From: Ben Daines [REDACTED]
Sent: 02 December 2019 12:10
To: Anita Gardner <Anita.Gardner@arun.gov.uk>
Subject: FW: EP/148/19/PL - Scorton Lime Tree Close, East Preston

Subject: EP/148/19/PL - Scorton Lime Tree Close, East Preston

The description of the application is therefore incorrect since the proposal also relates to amendments to the site layout/landscaping. I would therefore also appreciate your agreement to the proposed amended description 'Application for variation of condition no.2 imposed on planning permission EP/52/18/PL relating to amendments to patio areas and landscaping including provision of footpath to western boundary of site and boundary treatment and amended internal layout & external appearance of plots 4, 5, 6 & 7 to create an additional bedroom to each unit'.

Plot 4: Limetree Cottages.
Proposed Elevations, Floor
Plans, Roof Plan & Section

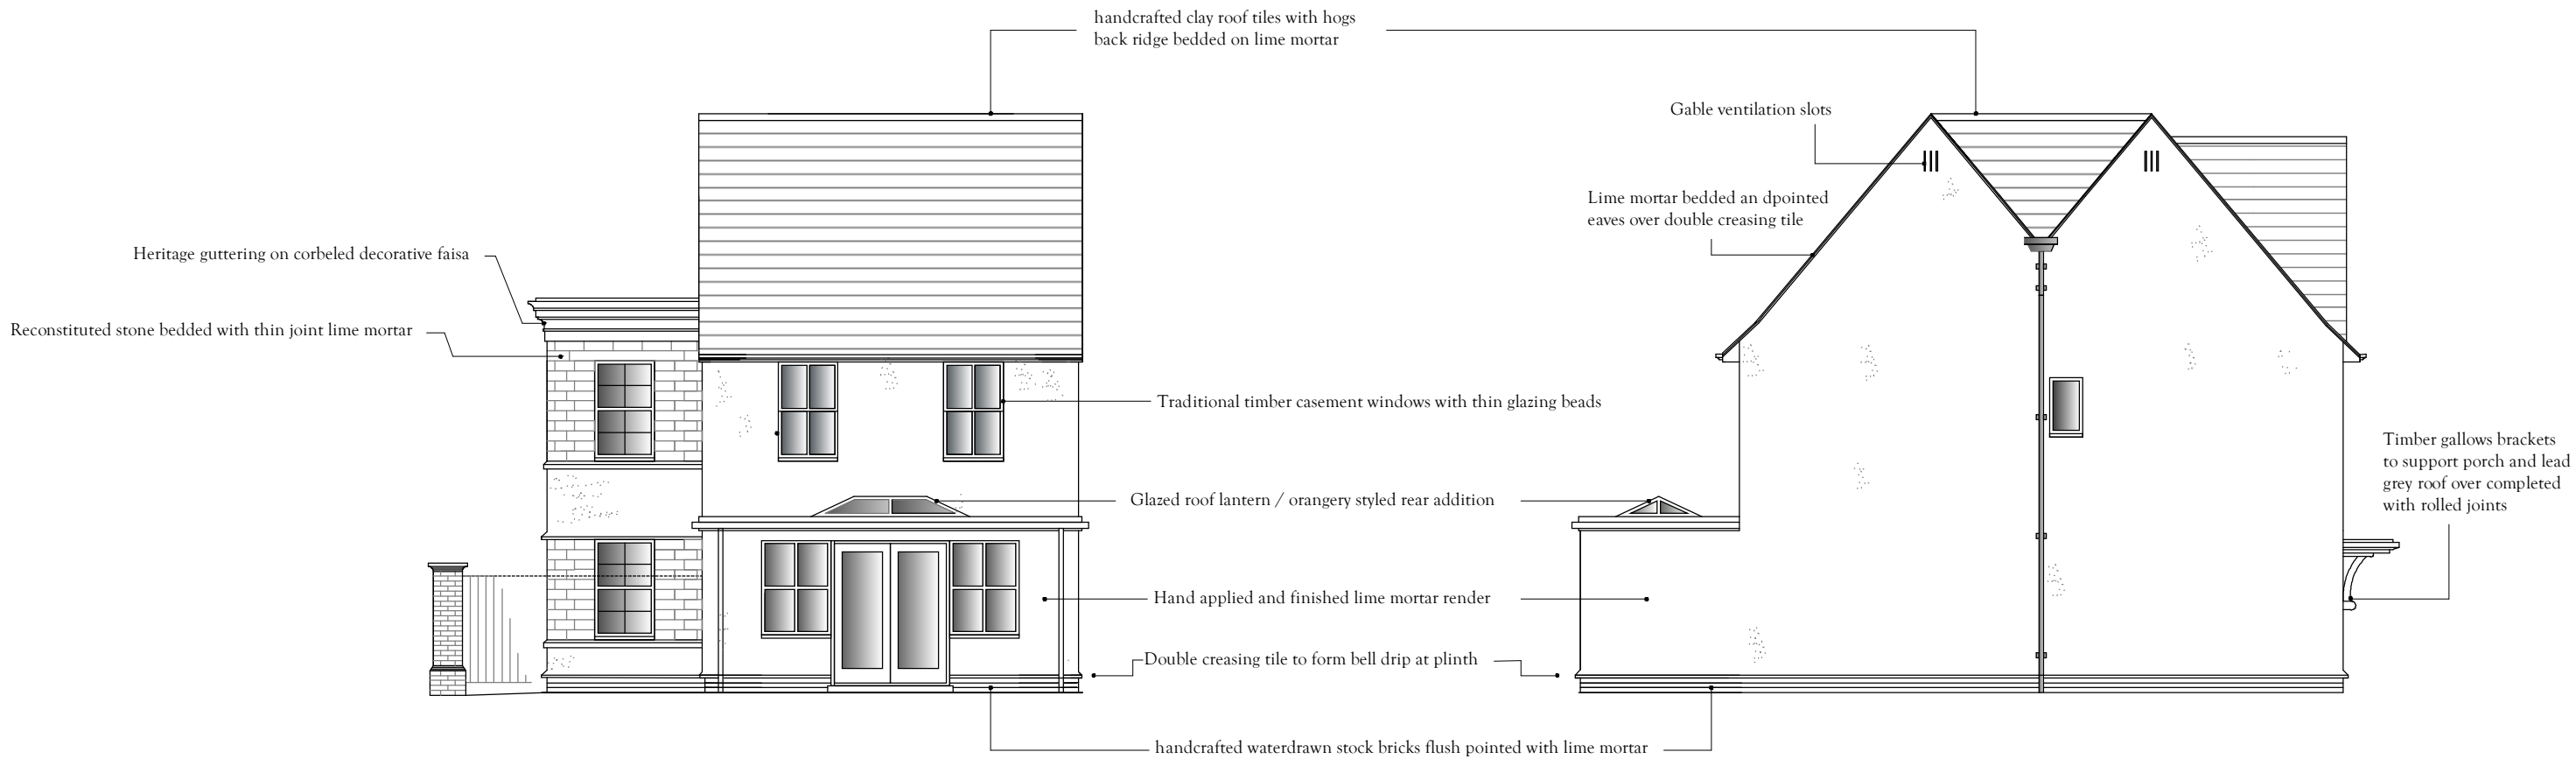
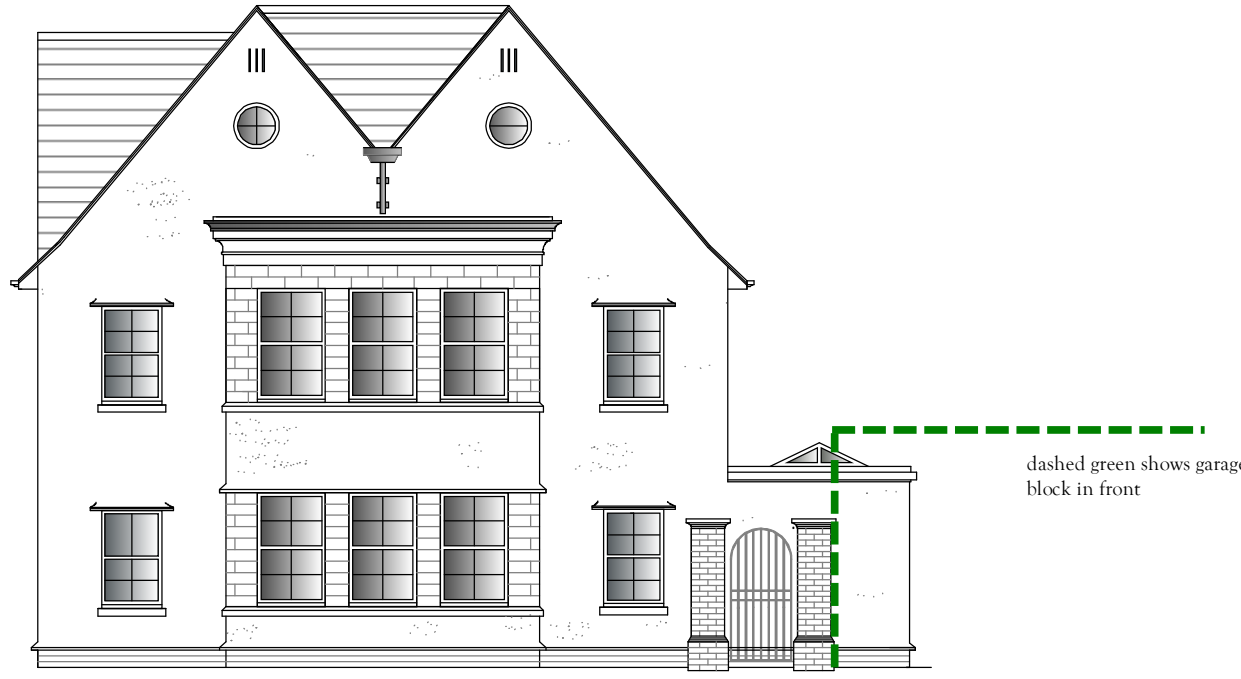
- On the layout plan The Cottage units fronting The Street indicate pitched roof dormers, although these do appear to have been approved on the elevations plan for EP/52/18PL they were not on the previously site approved layout plan.
- The notes on the elevations do not refer to the additional window in the south side elevation at first floor of plots 7, 5 and 6 or the additional roof lantern to the end plots.
- There are changes to the landscaping approved. In terms of species and at least one proposed tree has been altered to a hedge. The units fronting The Street now have additional patio areas indicated and there is a footpath added to the western site boundary.

- The first floor dormers are shown on the approved elevations drawings but were not drawn on the approved site layout plan, they have been added on Landscaping drawing LT.LAND.004.
- The first floor south windows are shown on the approved elevations drawings and agree there is no reference on the drawings for plot 7 & 4 regarding the additional roof lantern to the proposed new bedrooms as these are hidden in elevation view but can be seen from a birds eye view.
- The approved landscaping drawing agreed when dealing with the planning conditions shows the additional patio area for plot 3. The planting was also agreed when dealing with planning conditions with the only amendment on the current drawing being the hedging to plot 4 changing to Hornbeam from Beech which are visually almost indistinguishable to each other.
